CITY OF ALBUQUERQUE

RE: **Bruno Residence**
8001 Fuji Court
Grading Plan
Engineer's Stamp Date 1/13/17 (File: E10D029)

Based upon the information provided in your submittal received 01/13/2017, the Grading Plan is not approved for Building Permit. The following comments need to be addressed for approval of the above referenced project:

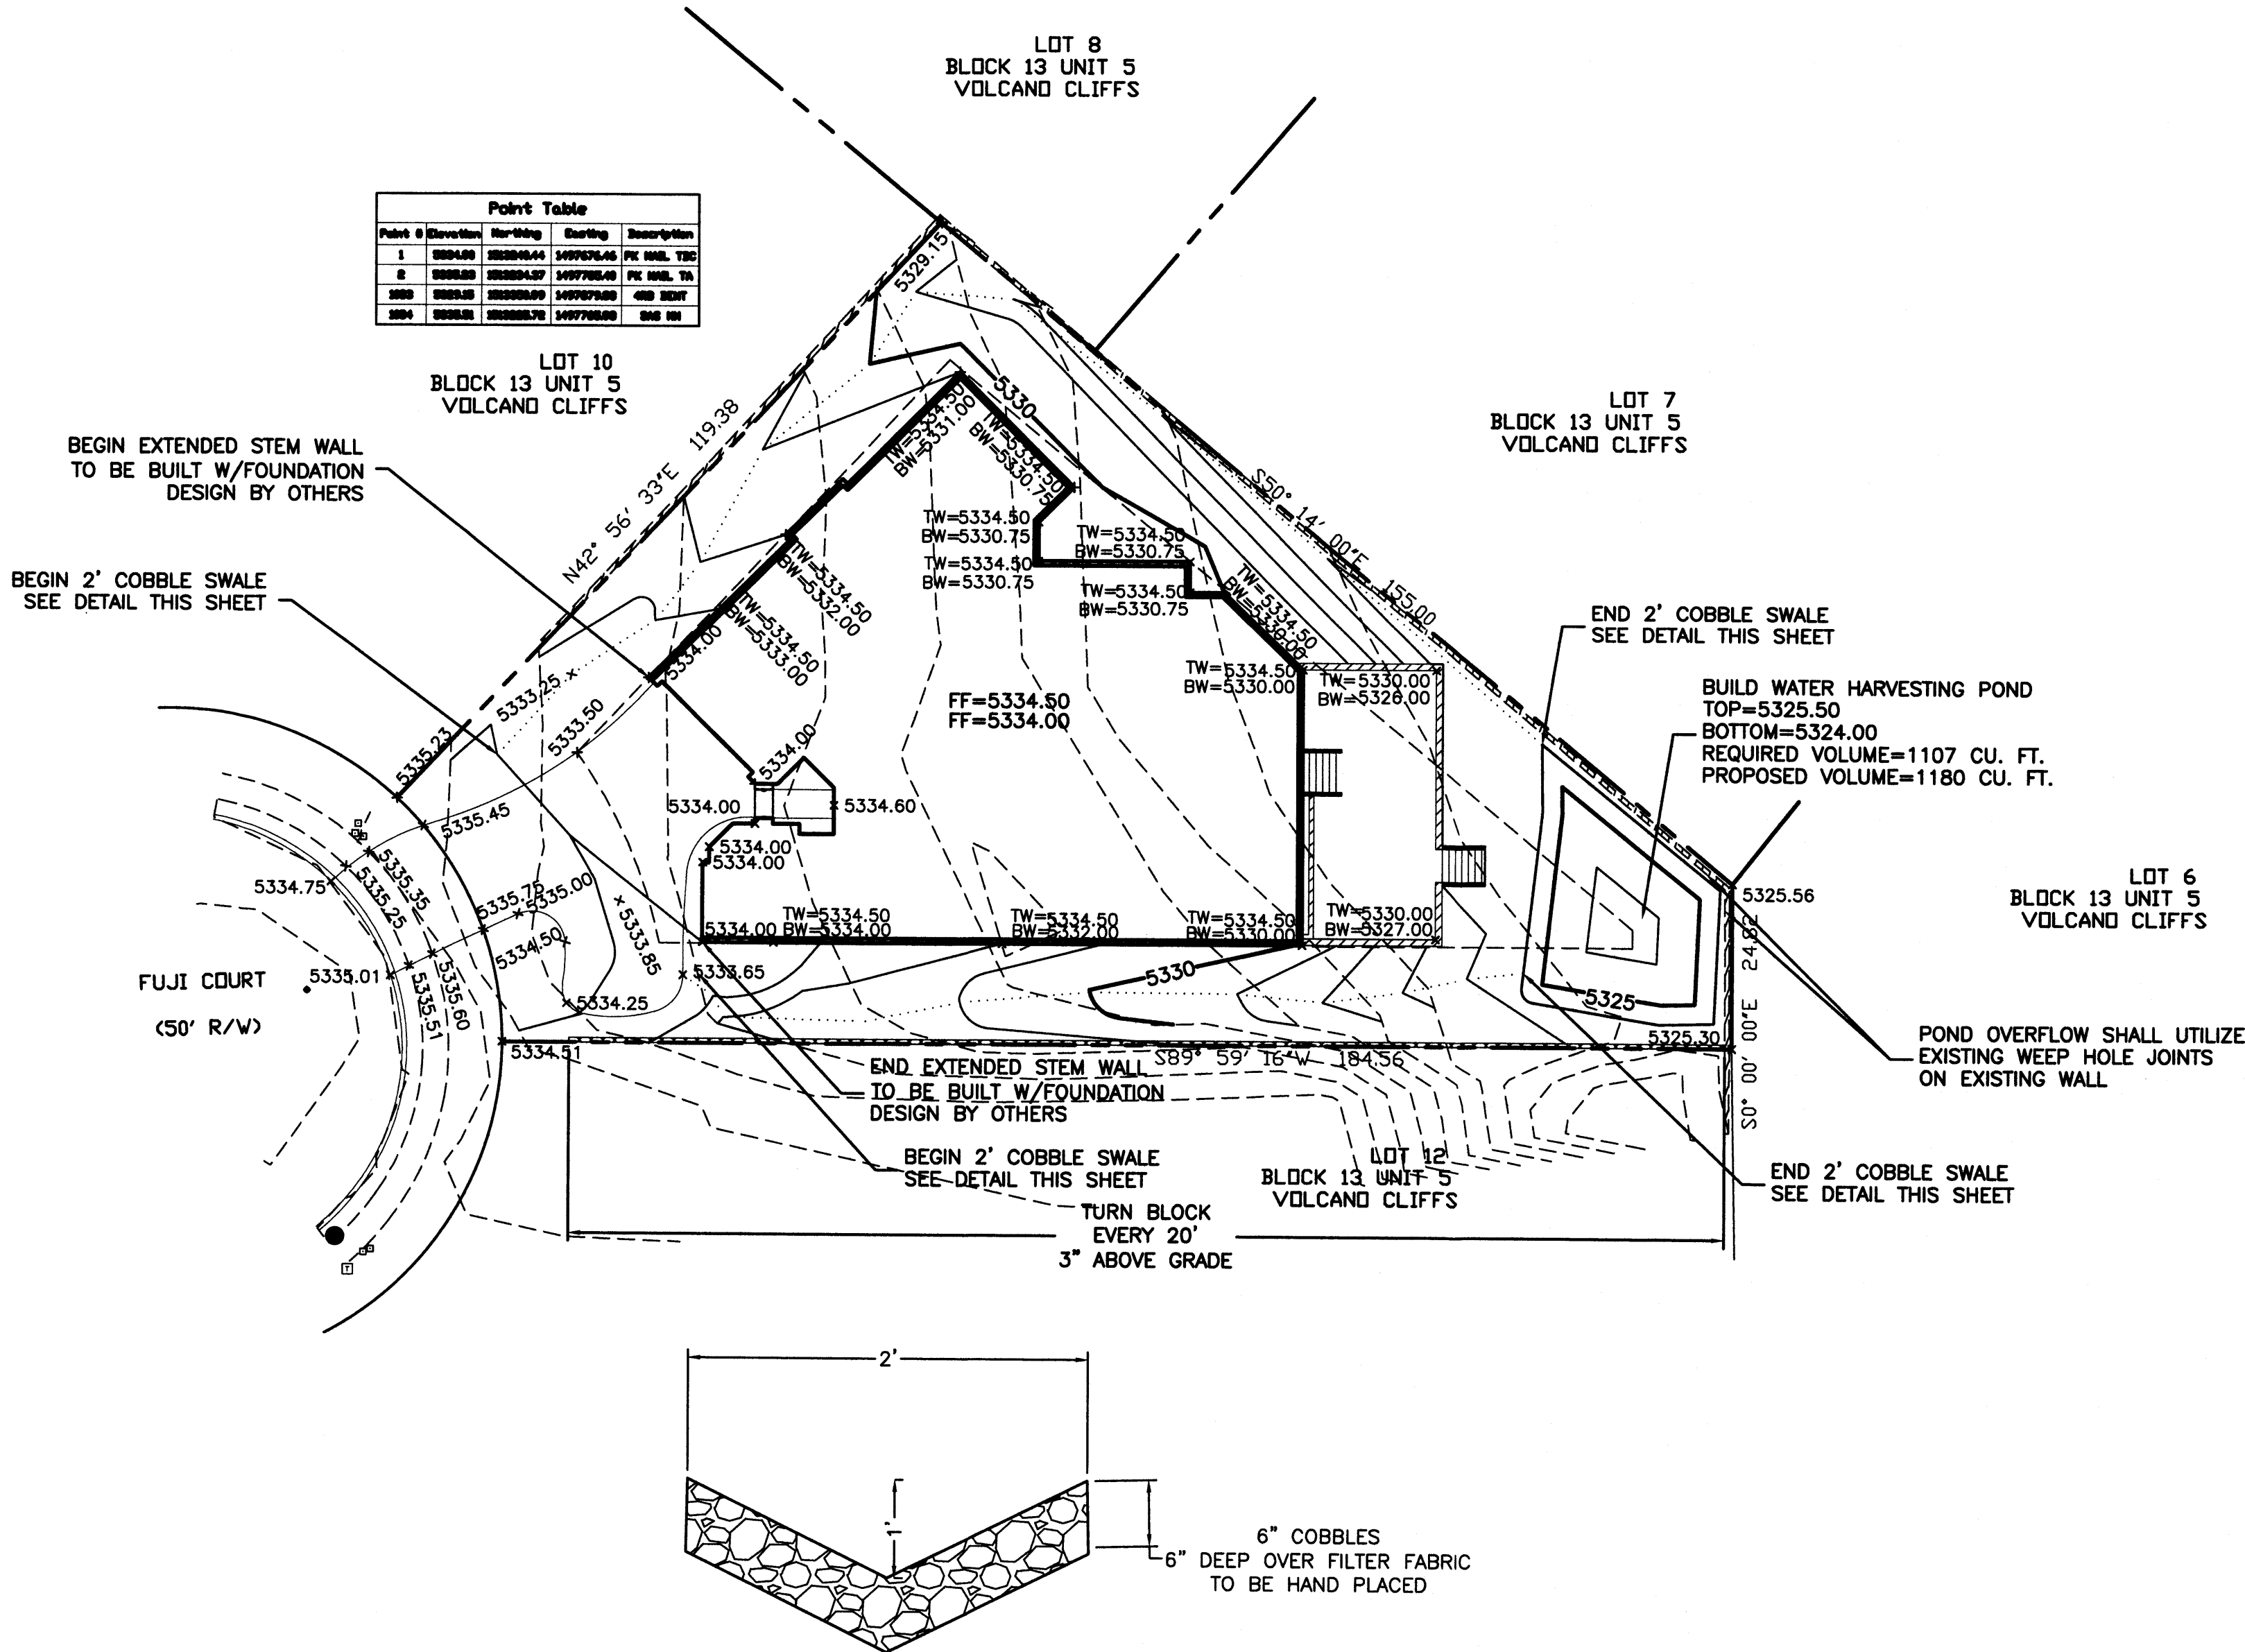
1. For historic flowpaths to adjoining lots, retain at least 50% of the proposed conditions 100-year, 24-hour event. Currently the pond is sized to hold only 633 cubic feet.
2. This site is within Special Assessment District 227, not 226, update the narrative to reflect.
